<b>Application reference number</b>	2025/0362
-------------------------------------	-----------

<b>Proposal Description:</b>	Installation of coal tub as mining memorial
<b>Location:</b>	Land to the west of 41 Lawrence Close, Higham, Barnsley

### Coal Tub Front and Rear Elevations

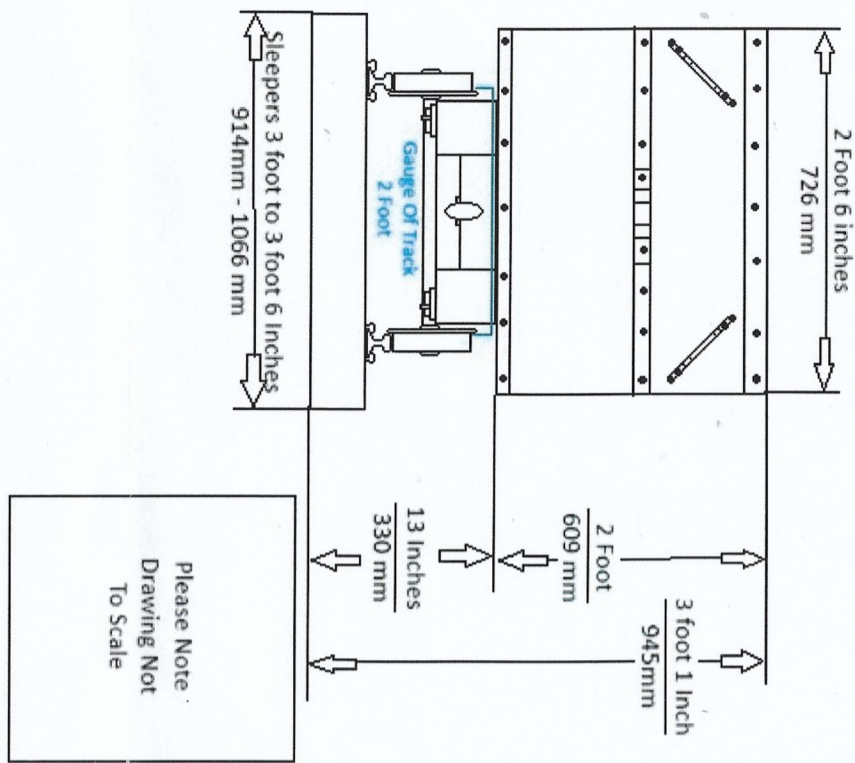
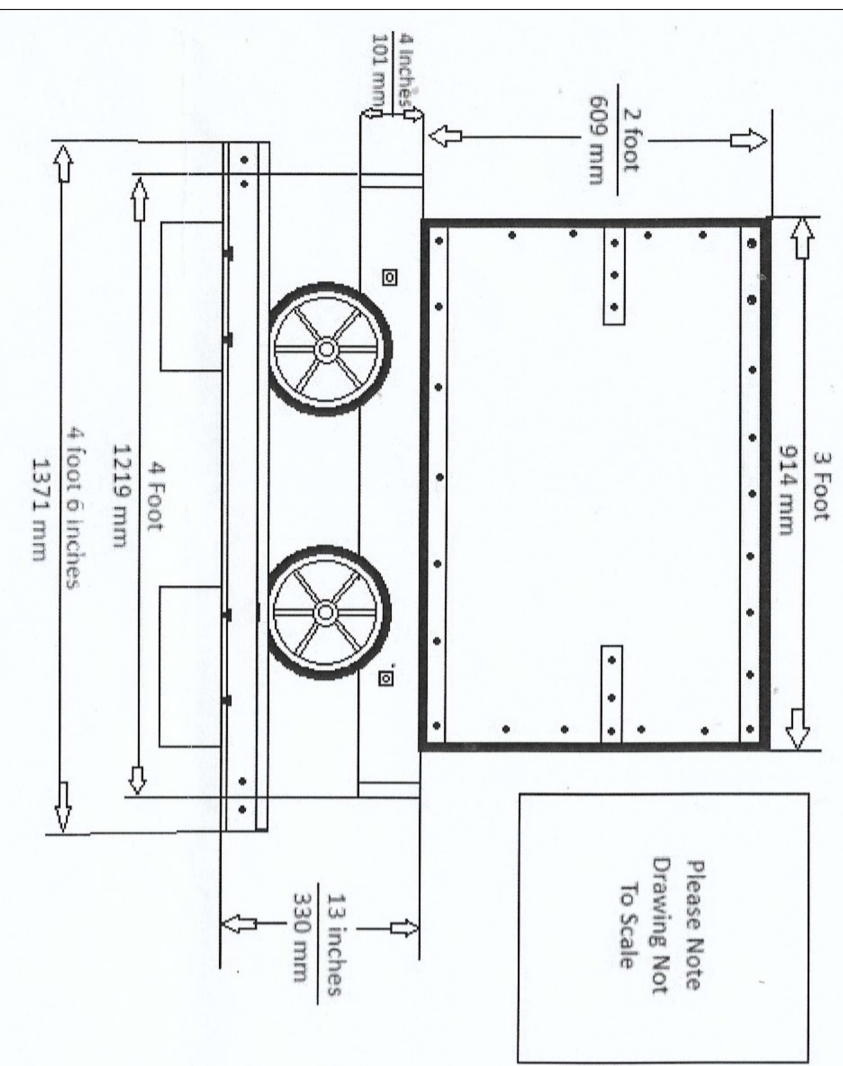
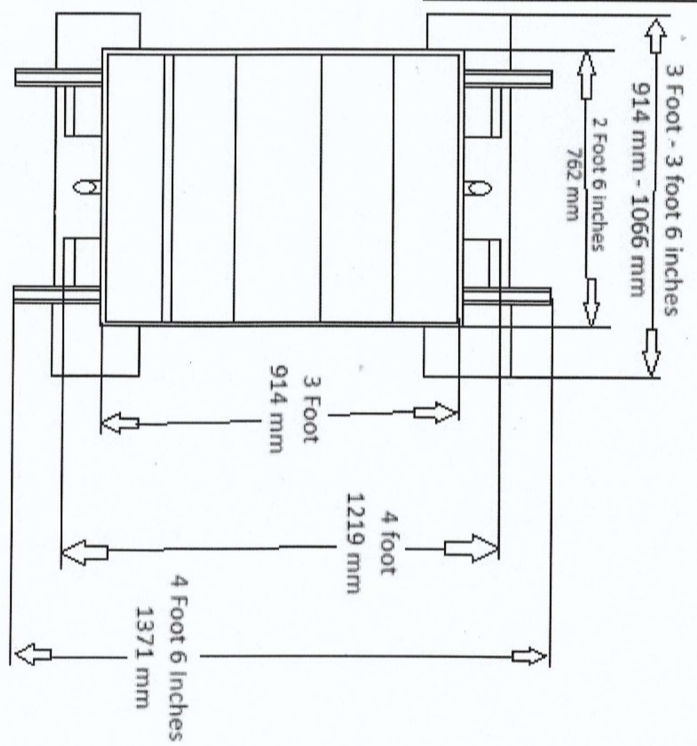
Highways Development Control have been consulted on the application and raise no objection to the proposal. However, they have raised concerns in relation to the sleeper base of the installation. The Council's Structures department would need to be comfortable with a wooden base for a metal structure when the former is likely to deteriorate more quickly than the latter. There is also the possibility of statutory undertakers' apparatus, such as gas mains, high voltage electricity cables and fibre broadband cables being located in the verge. Whilst the concerns raised are not material planning considerations and would have no impact of the planning permission at this time, information has been provided which suggests that the siting would not impede the location of statutory undertakers' apparatus. However, informatives will be included on the application to notify the applicant of their requirements, and should re-siting be required, a new application may be required.

Title: VISIBILITY SPLAY LAYOUT

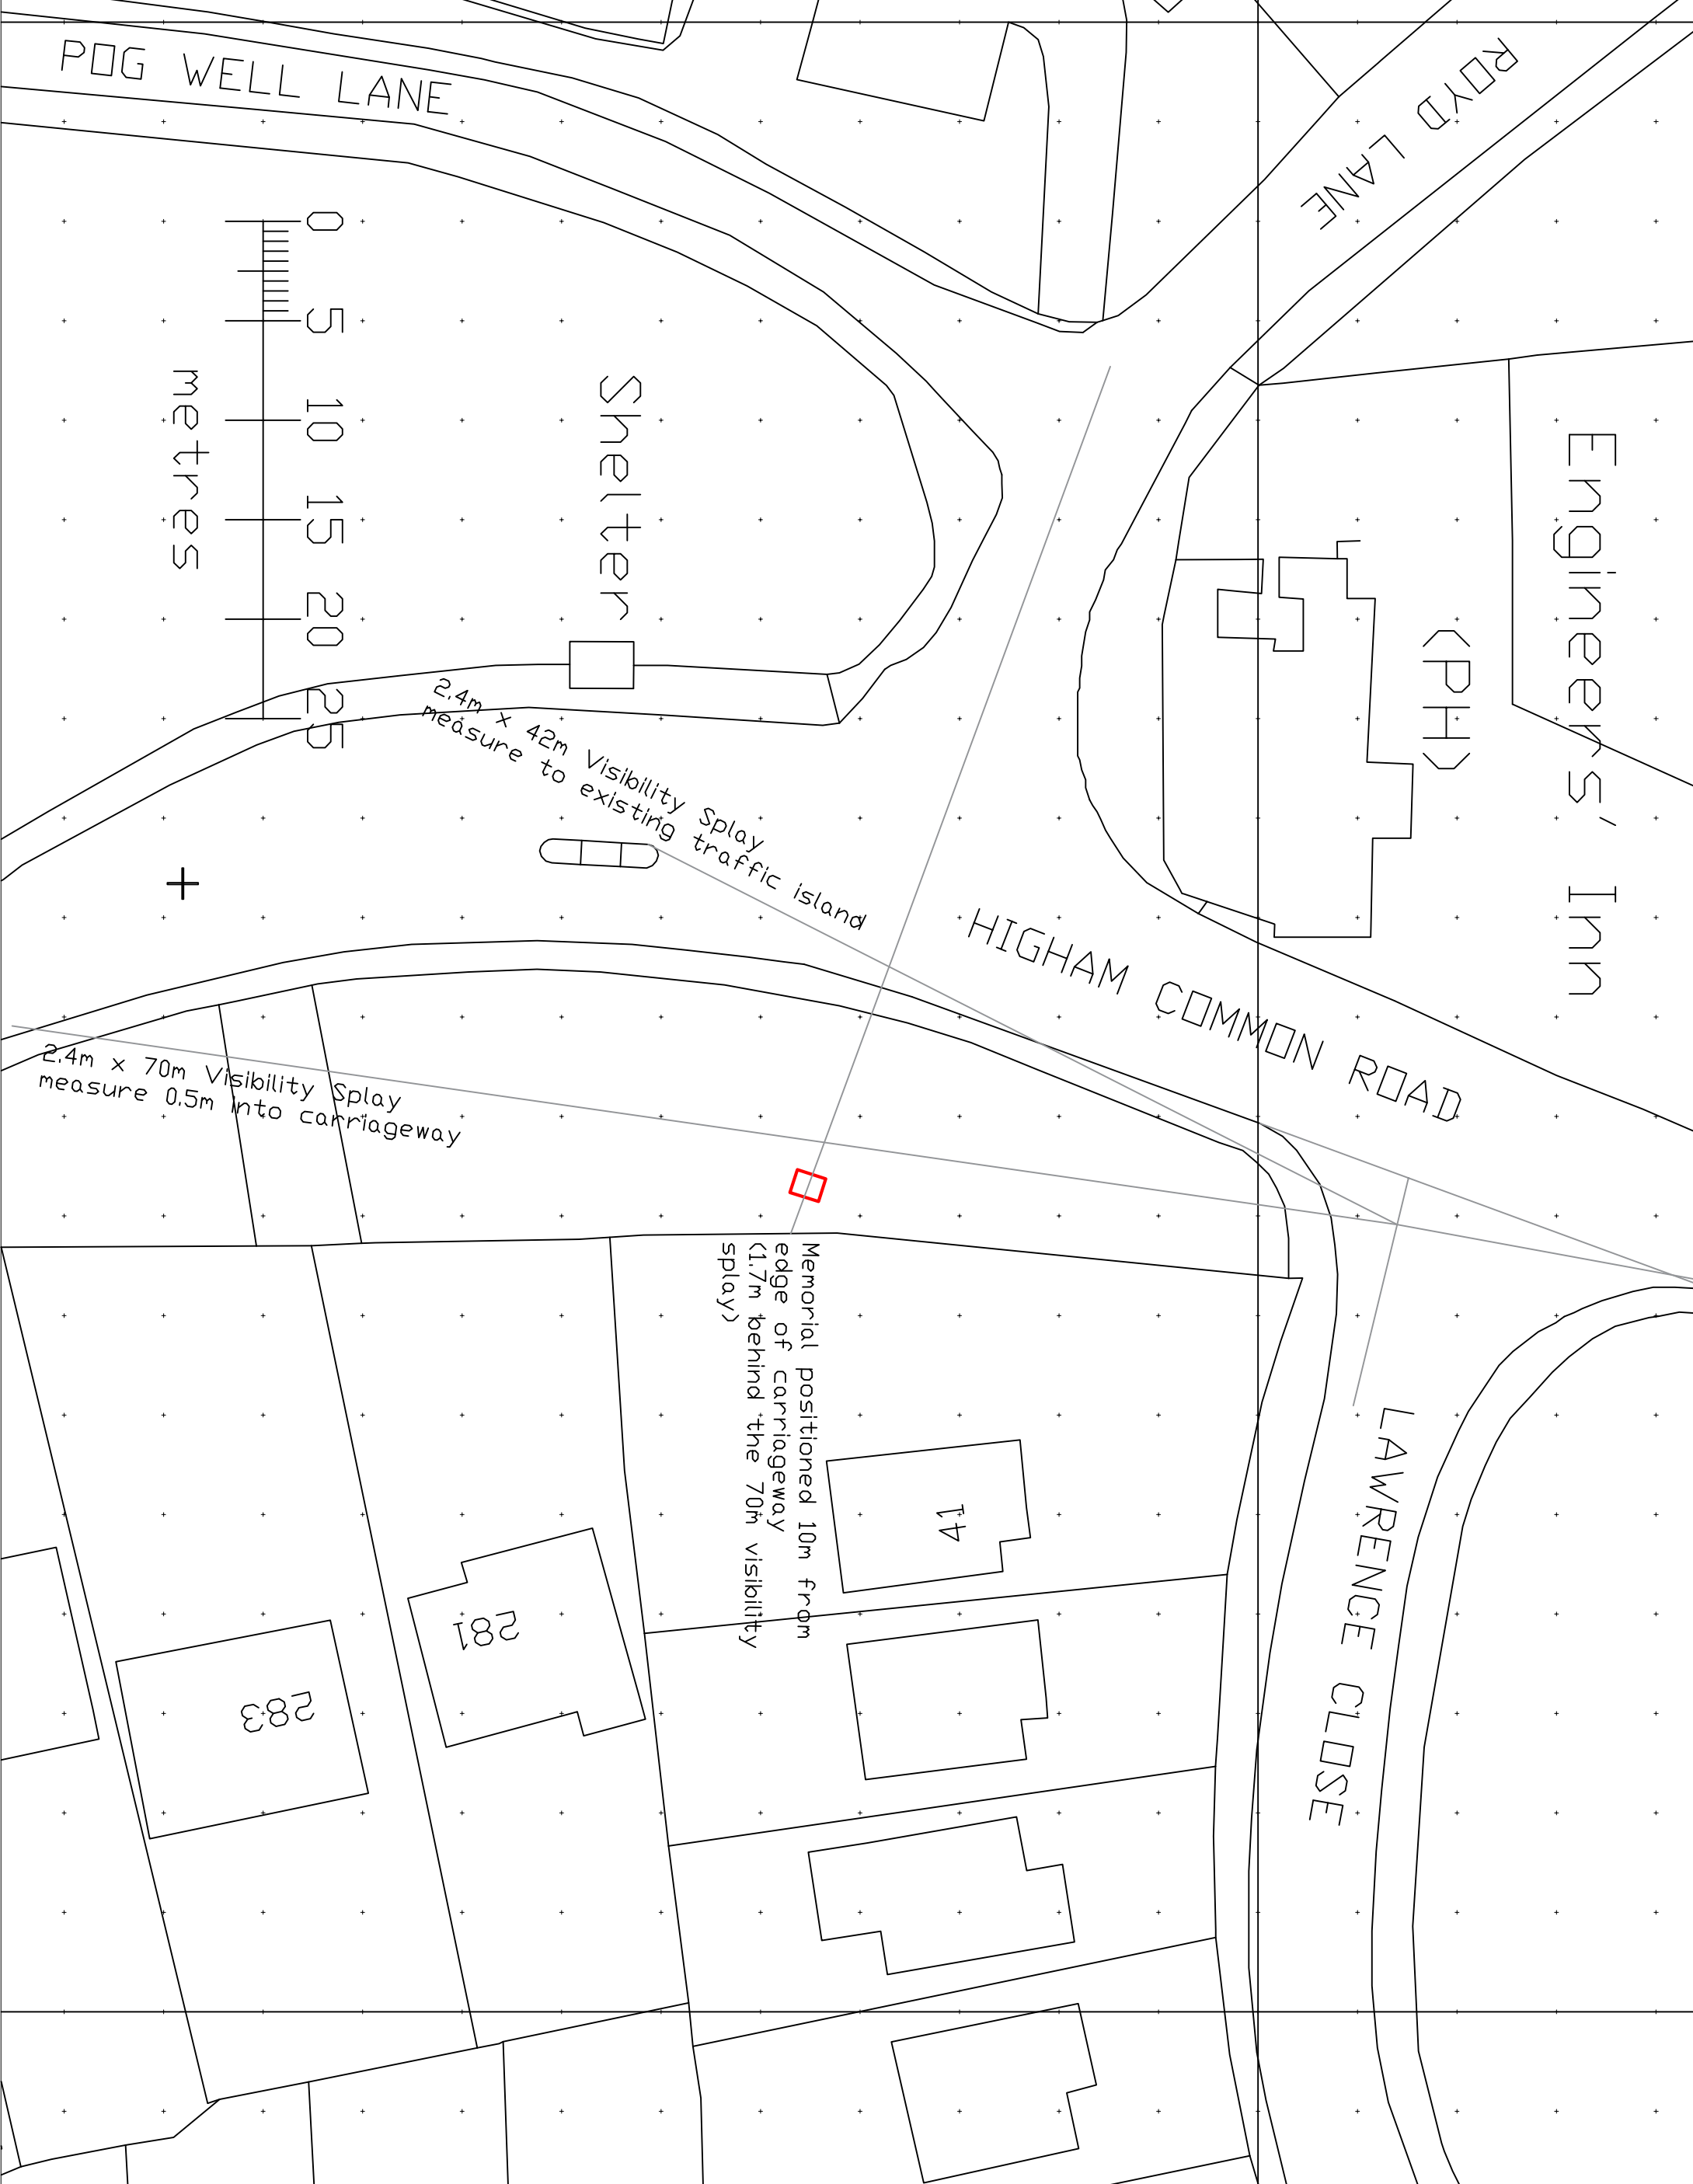
The proposed mining memorial coal tub is to be located within the grass verge to the east of Higham Common Road, and has been sited such not to impede the visibility splays of the user of the highway when exiting Lawrence Close on the Higham Common Road.
